From: Sue Howell
Sent: 27 February 2019 12:06
To: Planning.Responses
Cc: Anita Gardner
Subject: RE: Planning Consultation on FG/11/19/DOC

APPLICATION NO: FG/11/19/DOC

Site Address: 55 Sea Lane Gardens Ferring BN12 5EG

Description of Works: Application to discharge condition 4 (landscaping) and 9

02 Proposed Site Plan
1002 Scale: 1:200

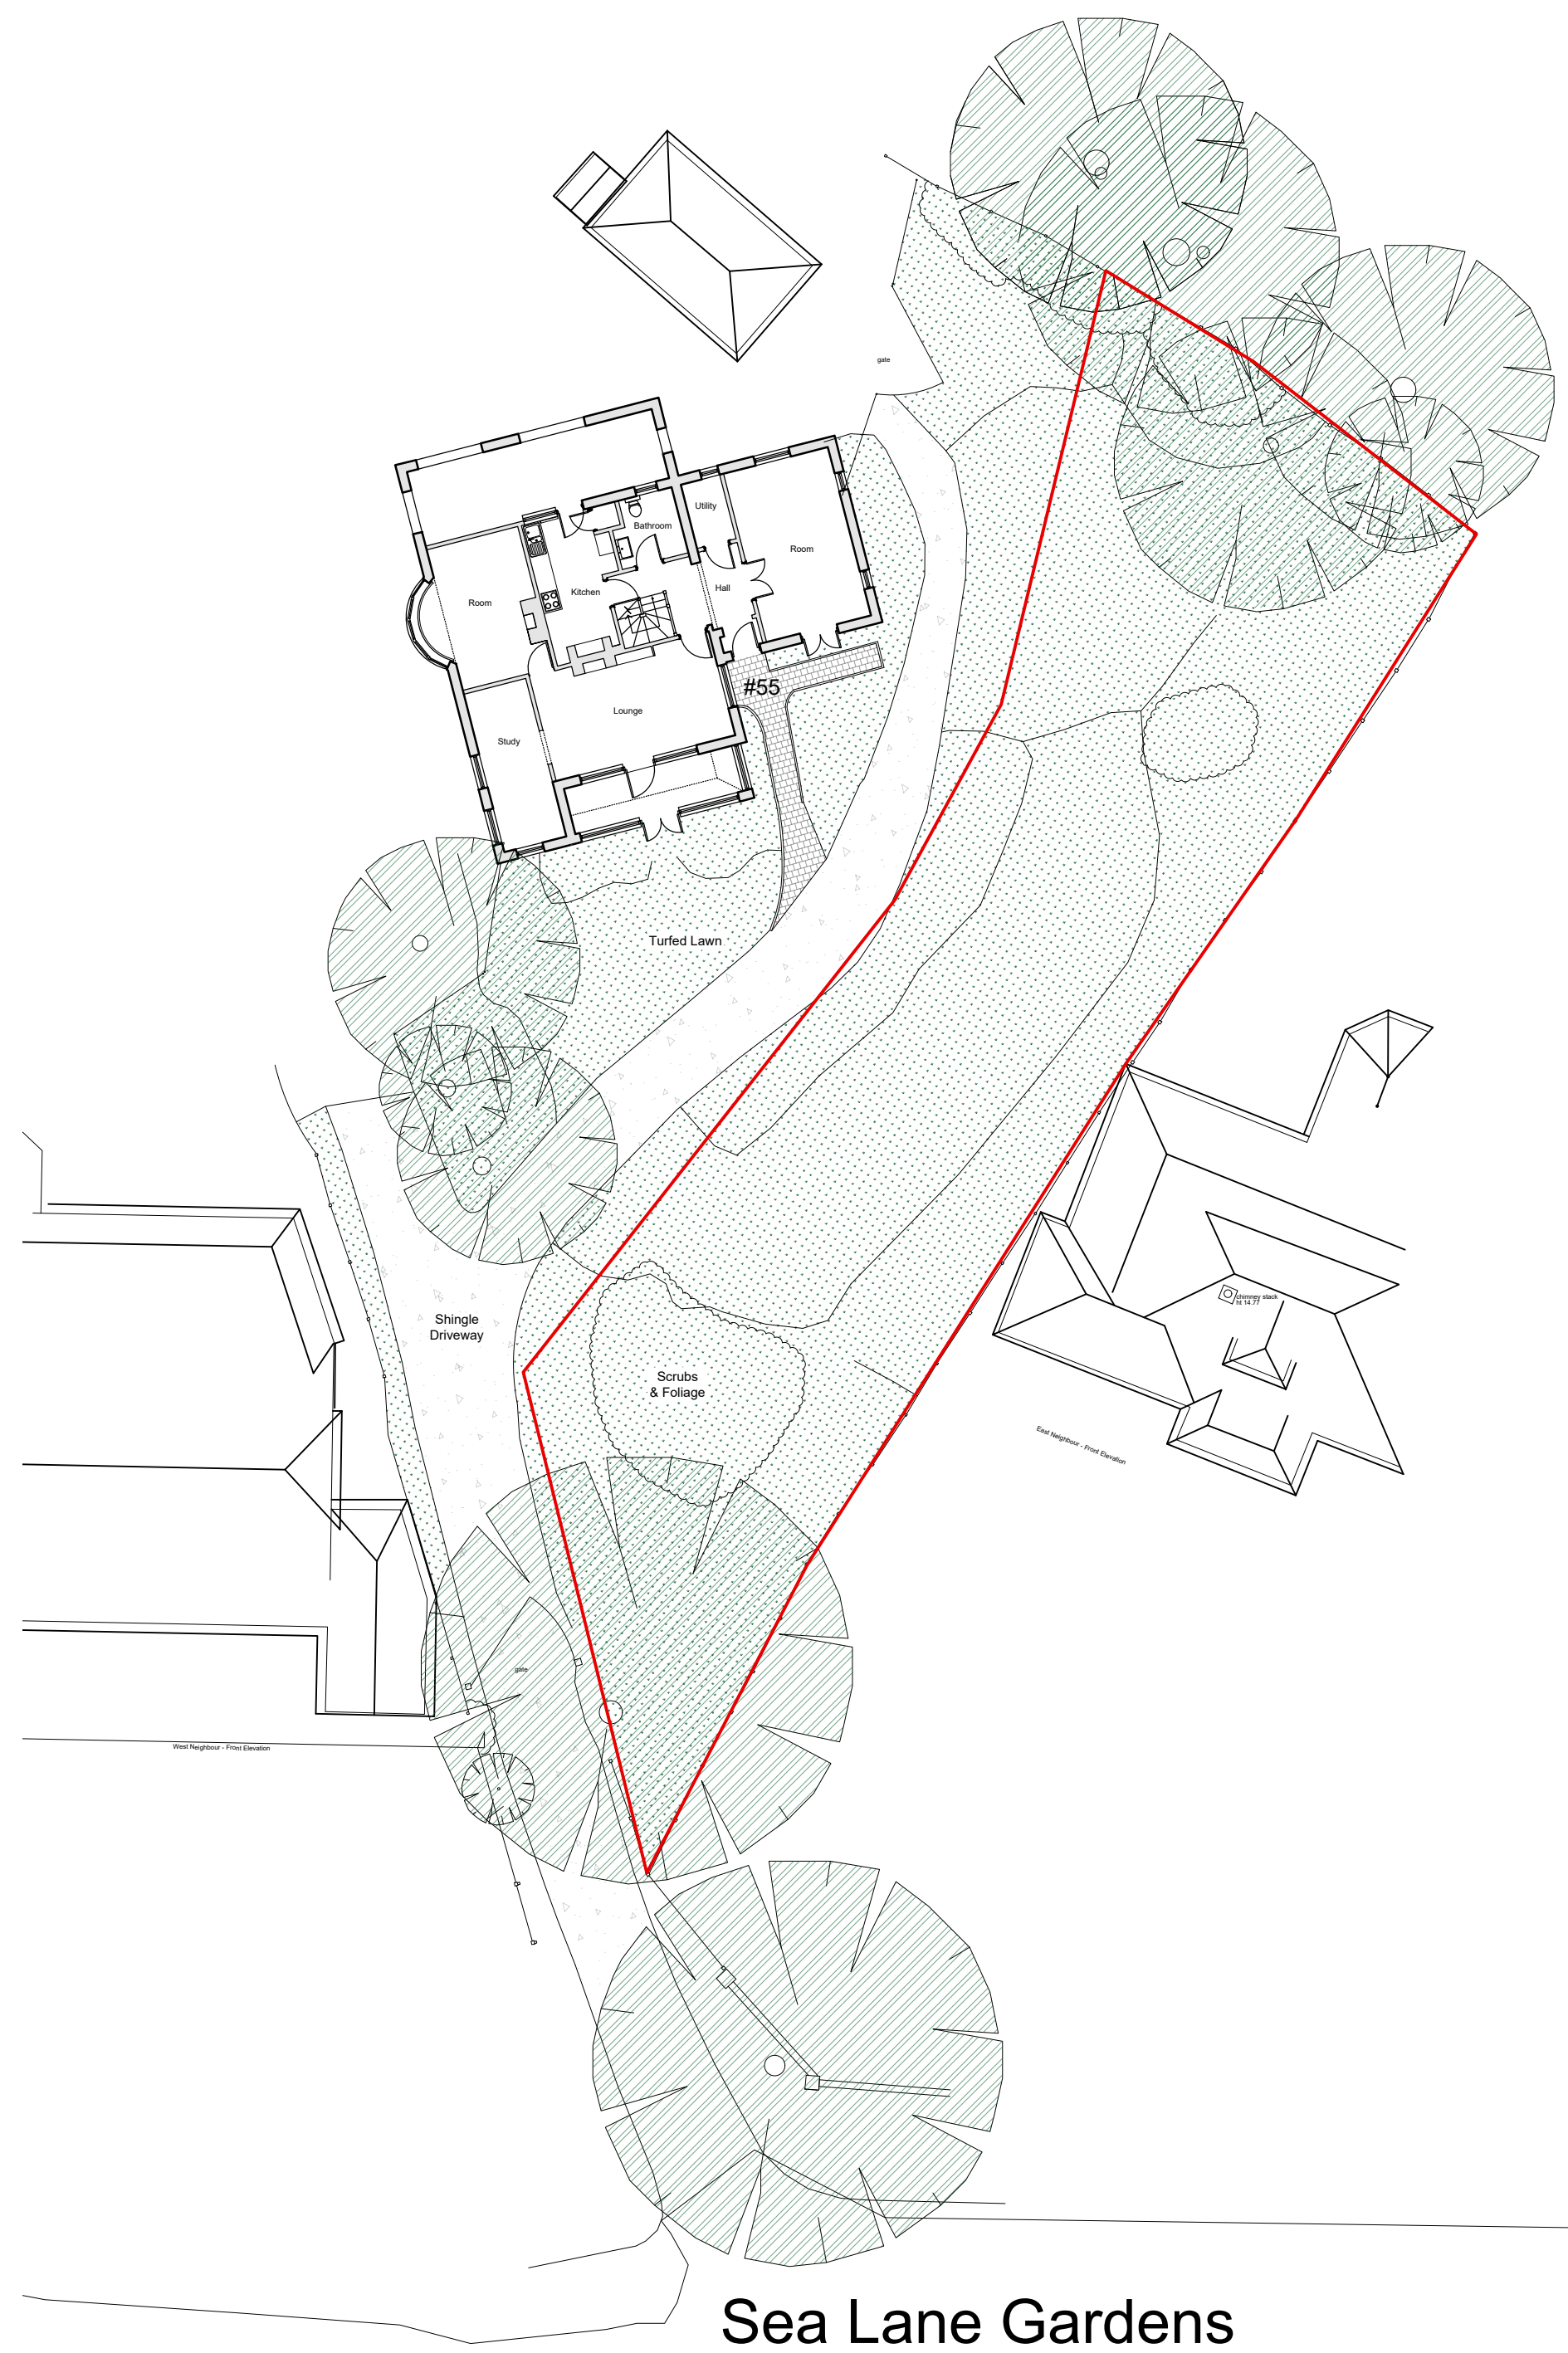
Further to submission of additional information re landscaping, I can confirm that the information supplied is sufficient in detail and that the plant choice is suitable in size and species for location. I would comment that the Photinia Red Robin whilst suitable should be checked on site re quantity (8no proposed) to ensure there are sufficient to effectively plant the areas shown for Photinia planting/hedging Dwg BBF 1002 01 and that they should be adjusted in number accordingly if found insufficient so as to fill the space and form the screening as intended.

I would therefore recommend the discharge of condition 4 on application FG/11/19/DOC imposed under FG/94/18/PL subject to providing the correct quantities required on site, noted above.
